CITY OF ALBUQUERQUE

**Re: Behavioral Health Hospital
1525 Renaissance Blvd NE
30-Day Temporary Certificate of Occupancy
Transportation Development Final Inspection
Engineer's/Architect's Stamp dated 10-8-18 (F16D051A)
Certification dated 2-4-20**

**BEHAVIORAL HEALTH HOSPITAL
RENAISSANCE CENTER
TRAFFIC CIRCULATION
LAYOUT**
2-4-20 Temp

ENGINEER'S SEAL	BEHAVIORAL HEALTH HOSPITAL RENAISSANCE CENTER TRAFFIC CIRCULATION LAYOUT	DRAWN BY DY
RONALD R. BOHANNAN P.E. #7868	TERRA WEST, L.L.C. 5571 MIDWAY PARK PLACE NE ALBUQUERQUE, NM 87109 (505) 858-3100 www.tierawestllc.com	DATE 10/02/18
		2017054-TCL
		SHEET # C6
		JOB # 2017054

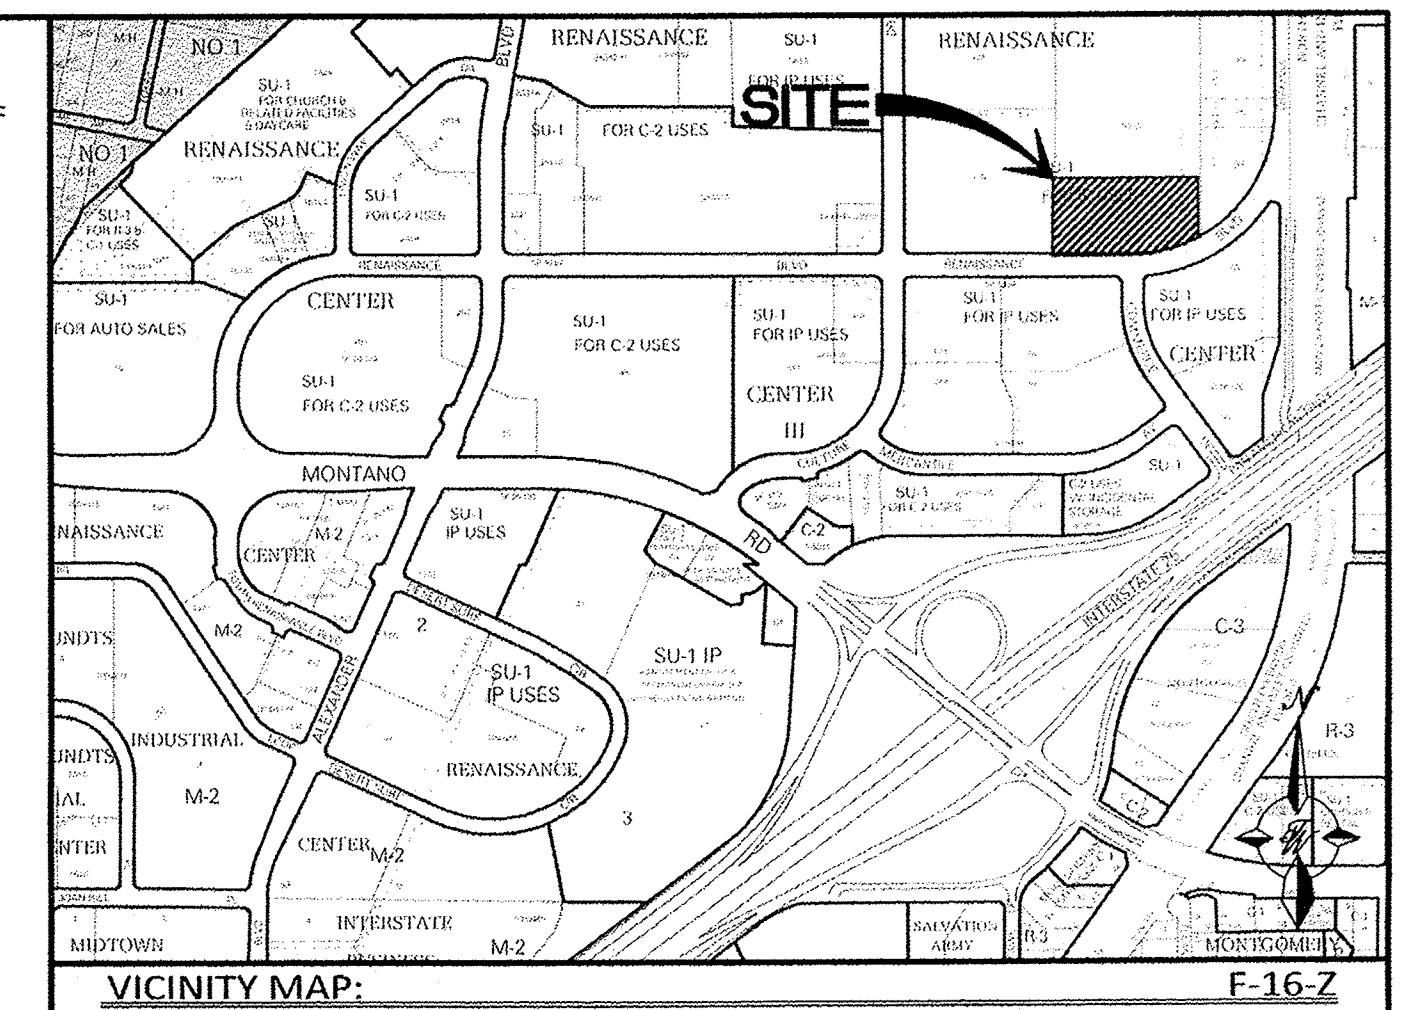
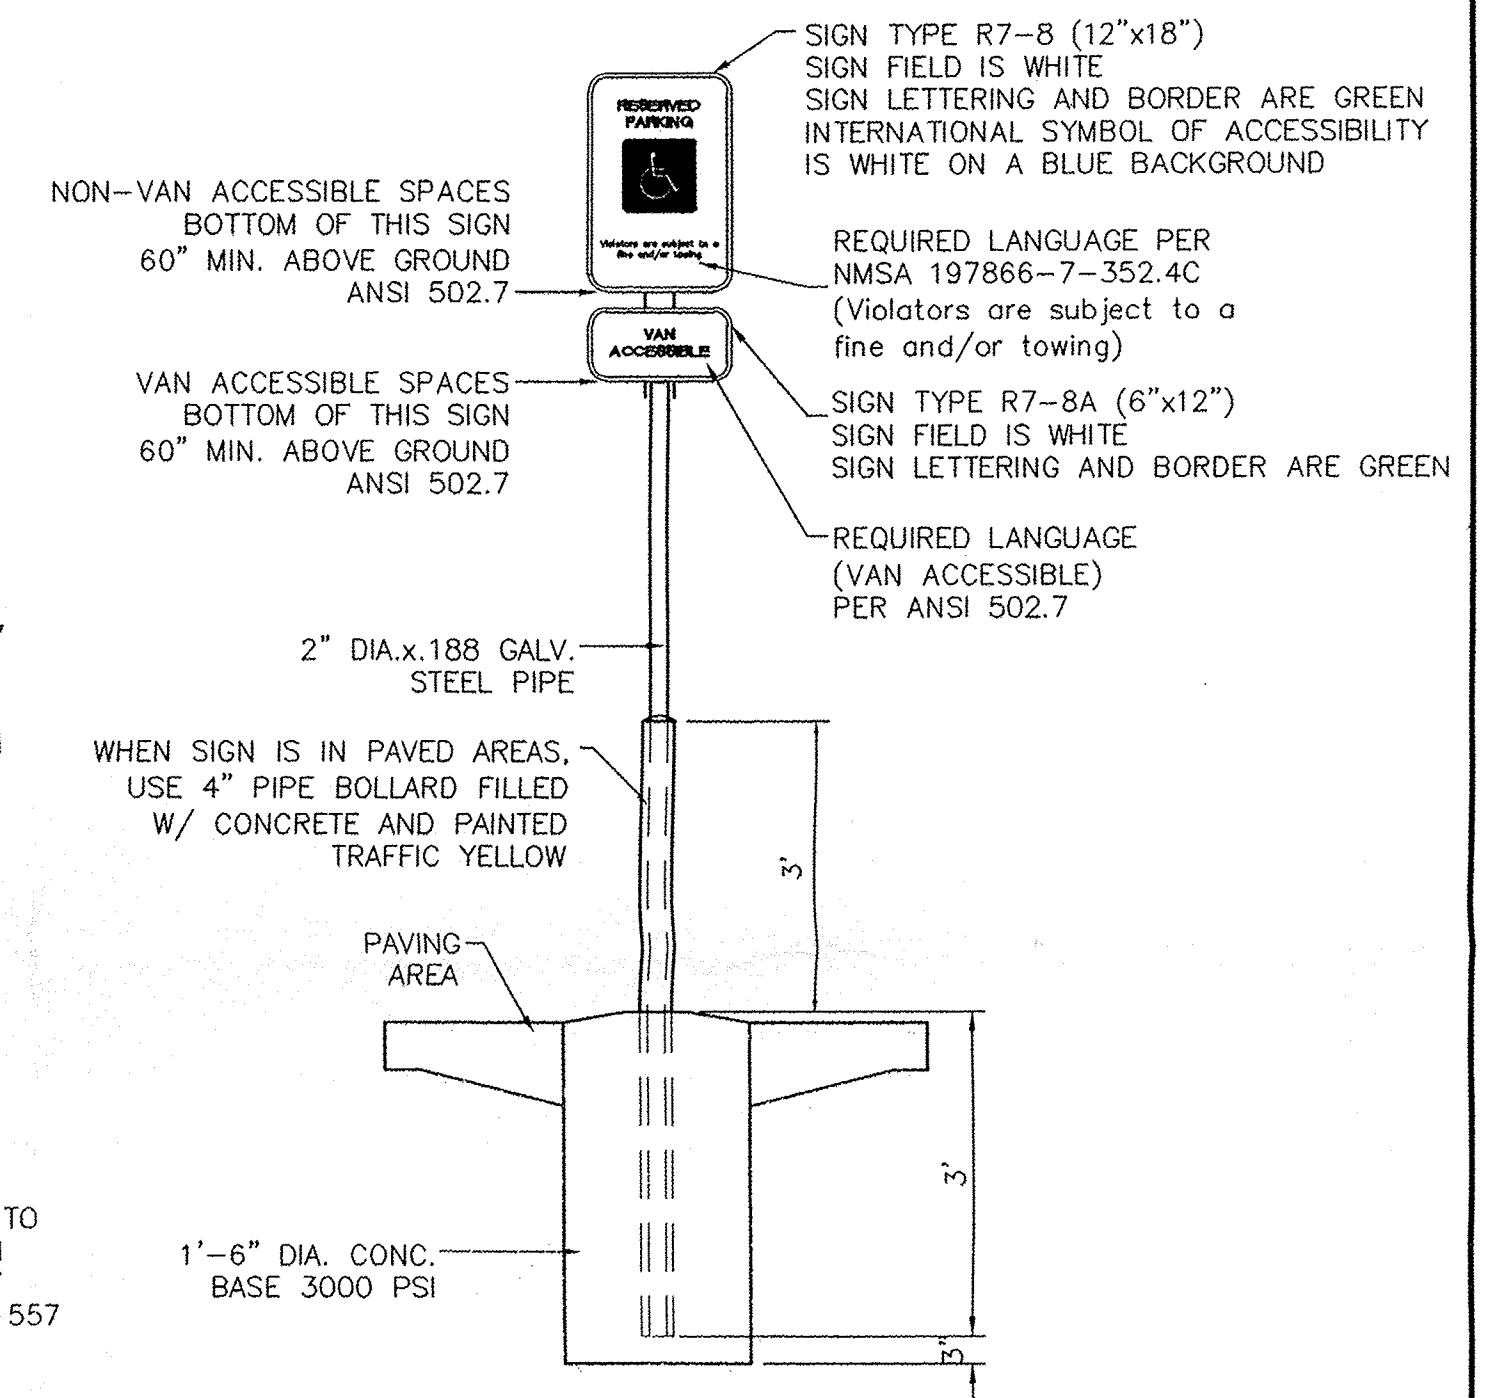
- Please fix buckled sidewalk (See attached photo)
- Please add top plate to sidewalk culverts around building (See attached photo)
- Please remove construction equipment and trash container.
